Wiswell PC

Planning Application:3/2025/0228, Stanacraft

SHEET:
PROPOSED ELEVATIONS

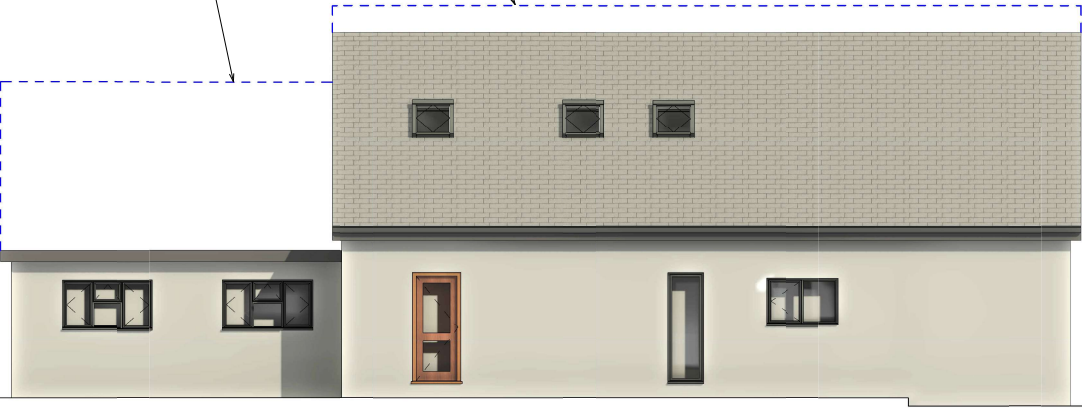
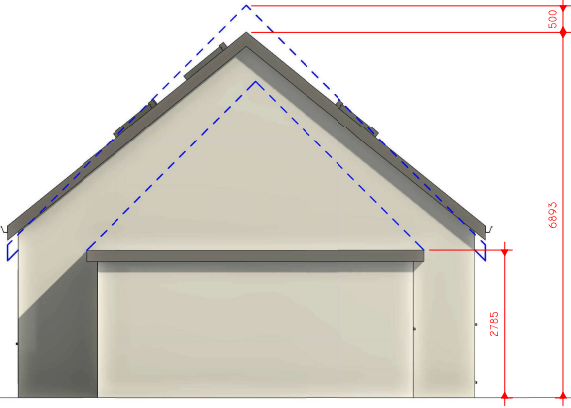
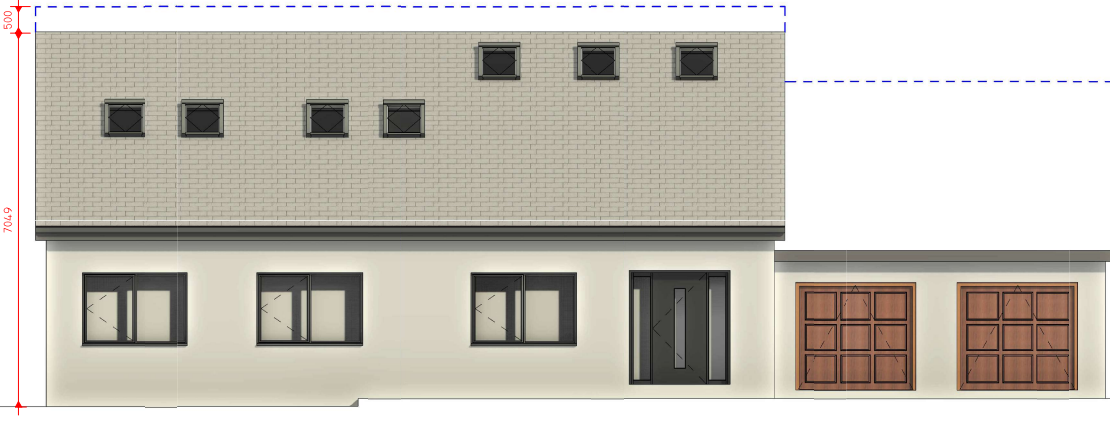
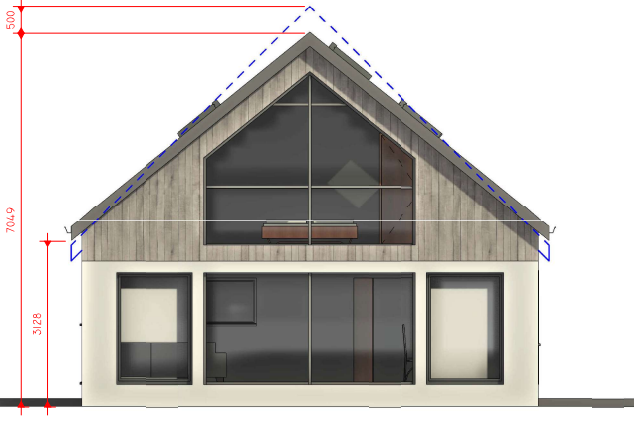
Since the Parish Council's last response an opportunity has been taken to consult with residents neighbouring the proposed development site. Residents welcome the decision to remove from plans the first floor extension over the existing attached garage and to reduce the overall ridge height of the new construction by 500mm.

We are however, aware of the fact that some residents have reservations regarding the adverse impact of the proposed elevation bordering the front garden of a neighbouring property, namely loss of privacy and light. Given the close proximity of the extension to the front garden of a neighbouring property this is understandable. In support of residents we ask developers to consider whether the height of the proposed extension bordering the front garden could be reduced.
